CITY OF ALBUQUERQUE

July 2, 2012

Re: Bruckner Truck Sales, Inc., Drainage Report and Grading Plan
Engineer's Stamp dated: 6/21/12 (H-18/D018)

36" SD HEAD WALL - SECTION A-A

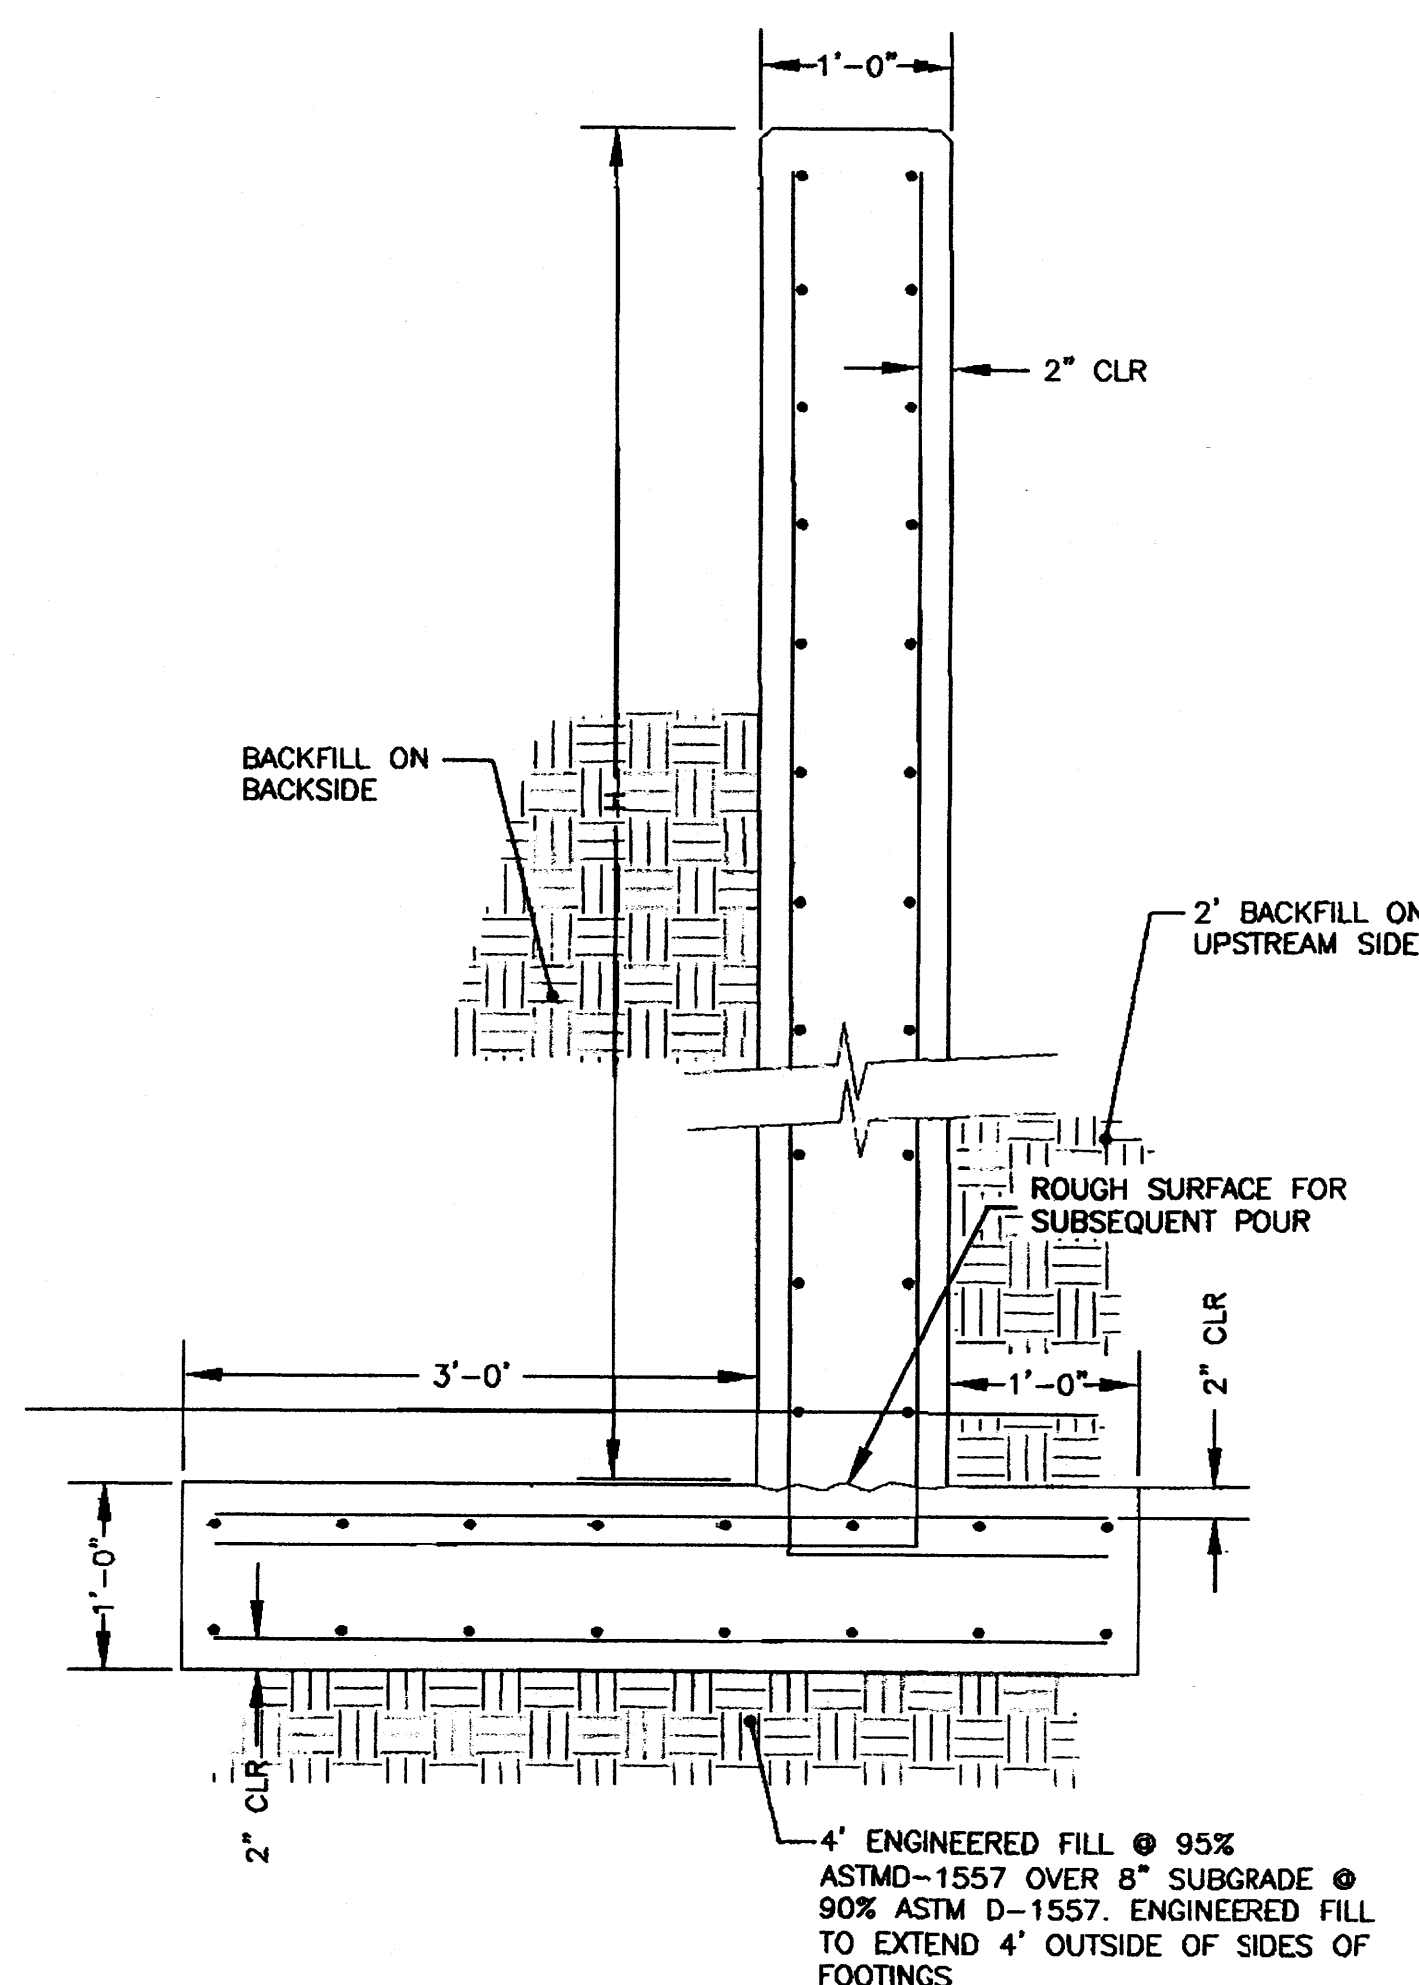
- Please provide a detail of the area around the cul-de-sac so it is easier to see the proposed grades. The report and detail sheet indicate a water quality inlet in a sedimentation pond upstream of the cul-de-sac. This is not clear on the grading and drainage plan.

ENGINEER'S SEAL  RONALD R. BOHANNAN P.E. #7868	BRUCKNERS TRUCK SALES GRADING AND DRAINAGE STORM DRAIN  <i>TIERRA WEST, LLC</i> 5571 MIDWAY PARK PLACE NE ALBUQUERQUE, NM 87109 (505) 858-3100 www.tierrowestllc.com	DRAWN BY BJF
		DATE 9/20/12
		2011073_GRB
		SHEET # C2.3
		JOB # 2011073

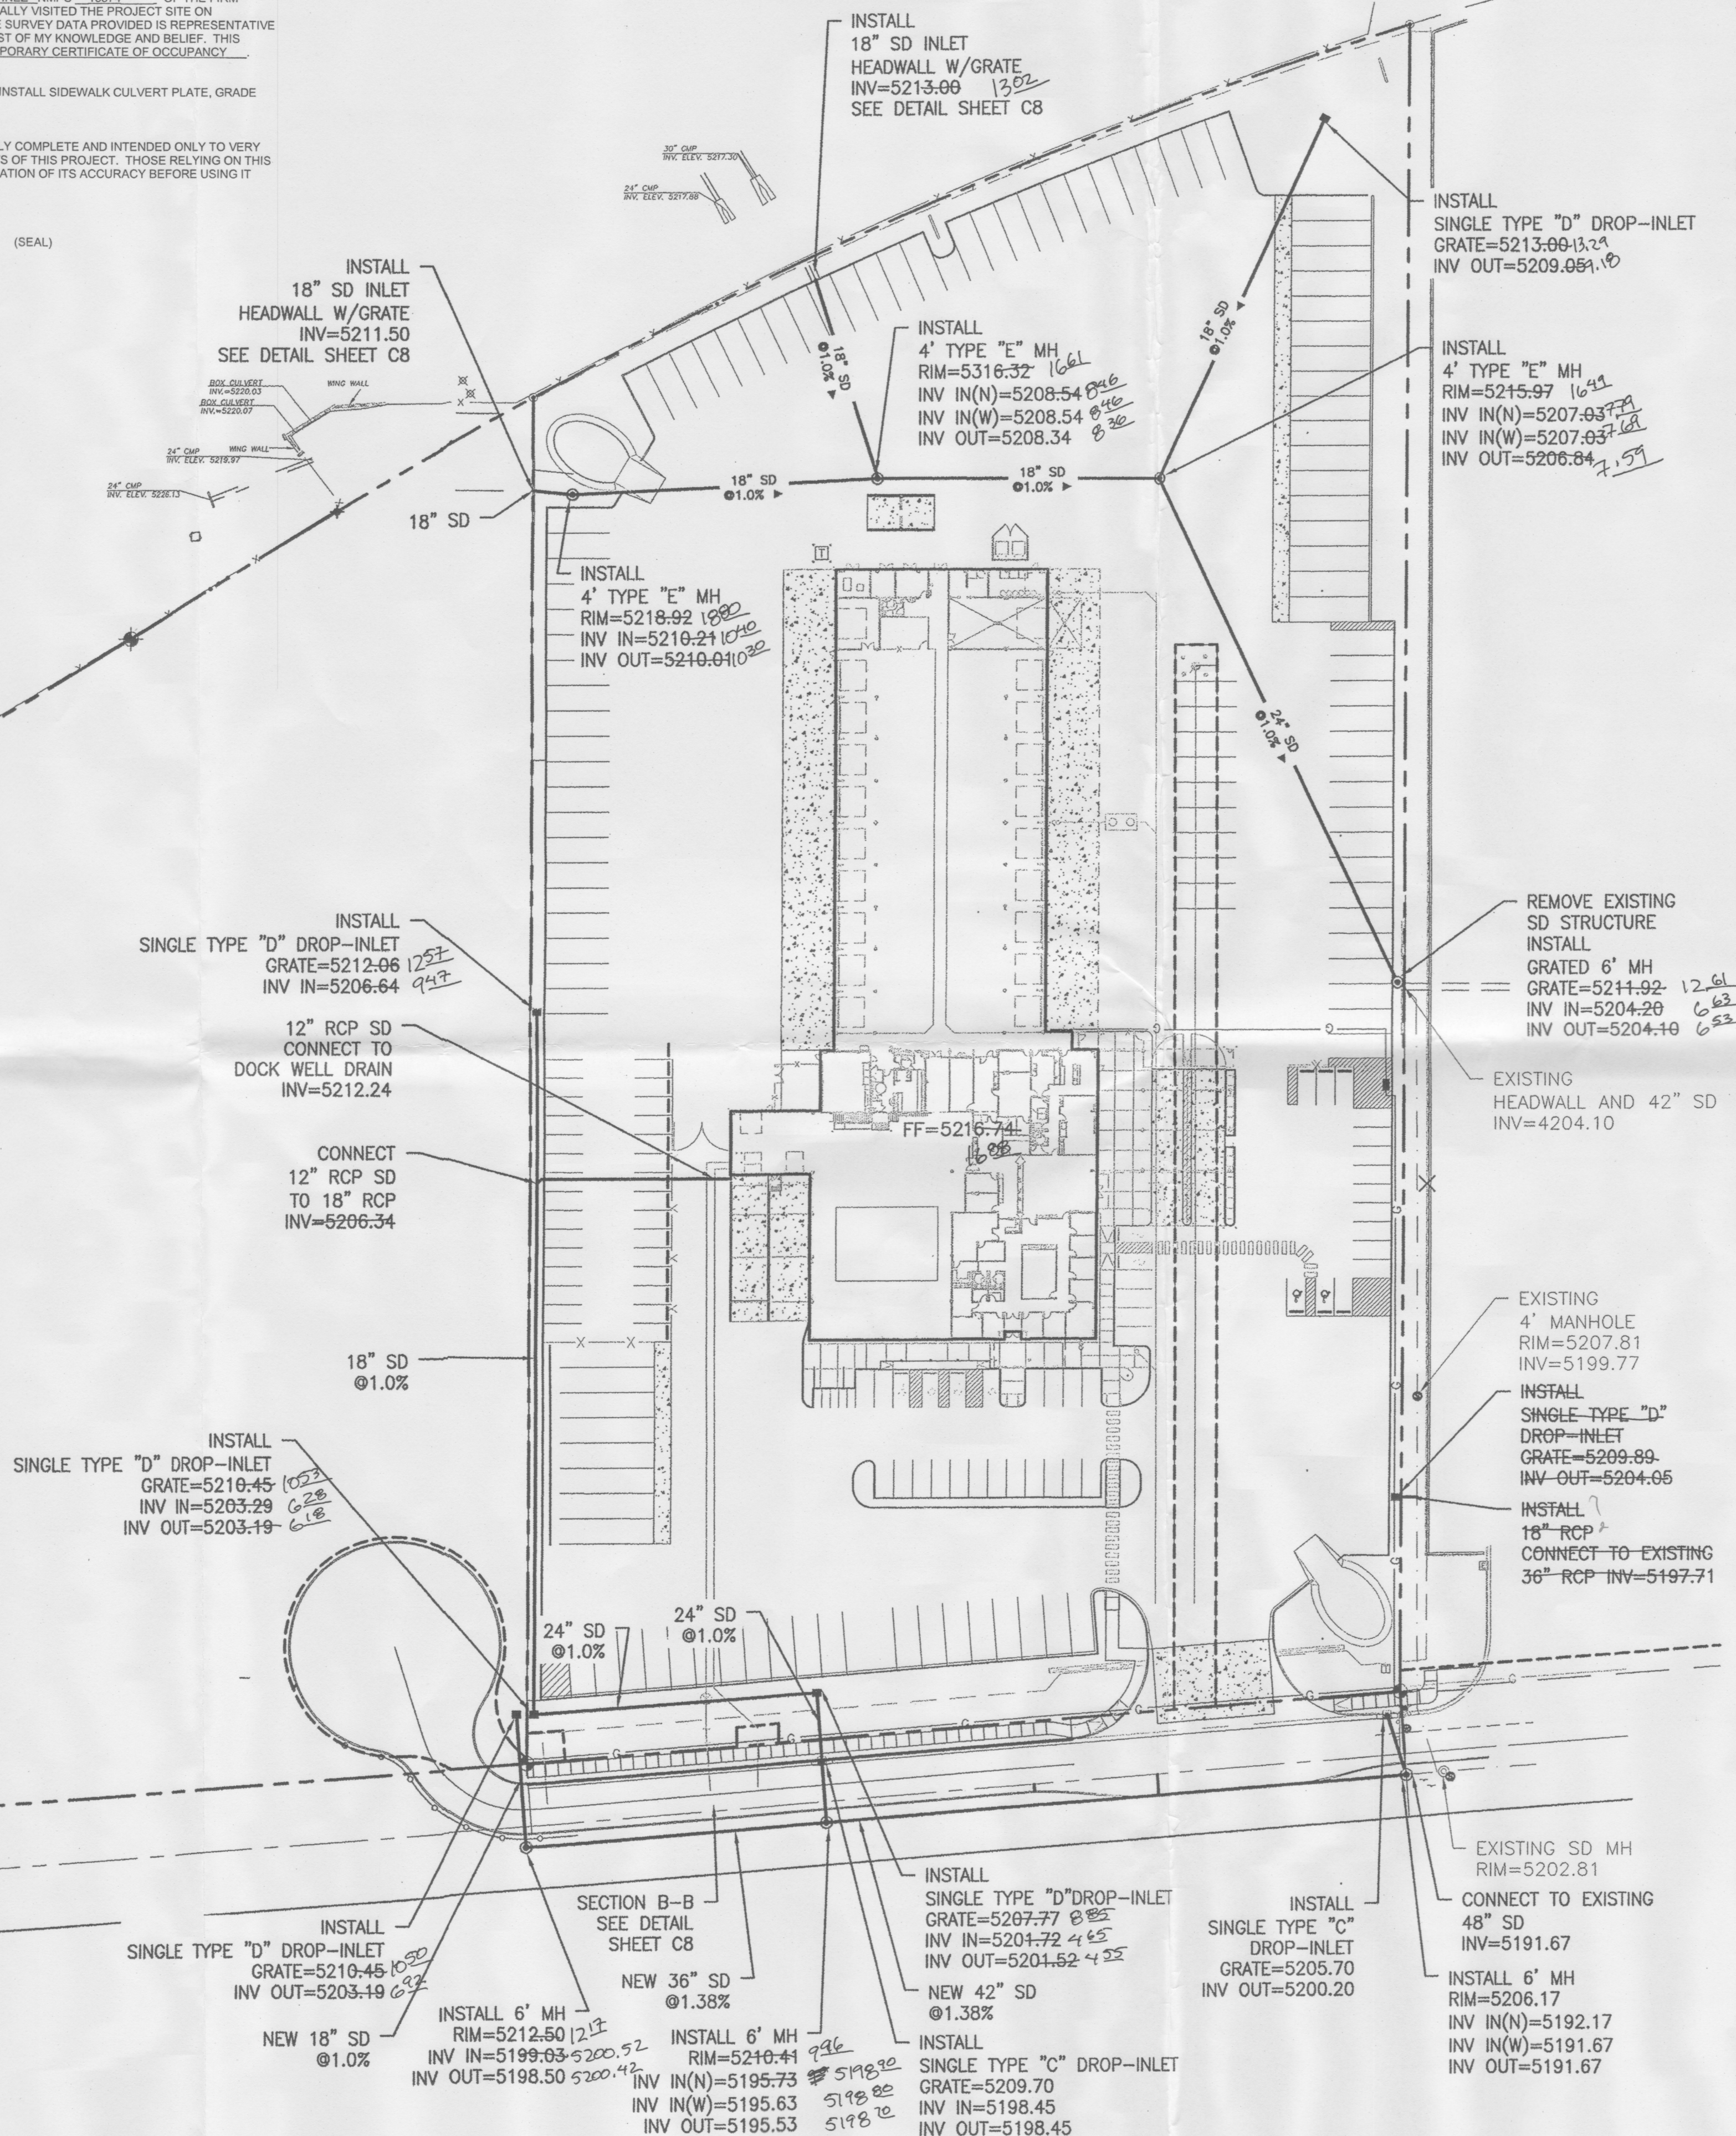
- Is T20 a manhole? The rim is shown 8 feet below grade.
- The rim values on the grading plan are 11 feet lower than on the Daytona Storm Drain Extension profile.

- Per the predesign conference, please include the time table for the I-40 interceptor project.
- What will the arroyo drainage structure look like when Daytona Rd. is extended to the west? Will the arroyos be picked up onsite, then drain south to the Daytona Rd. storm drain? Hydrology would like to know if Pipe P11 is proposed as permanent or temporary.
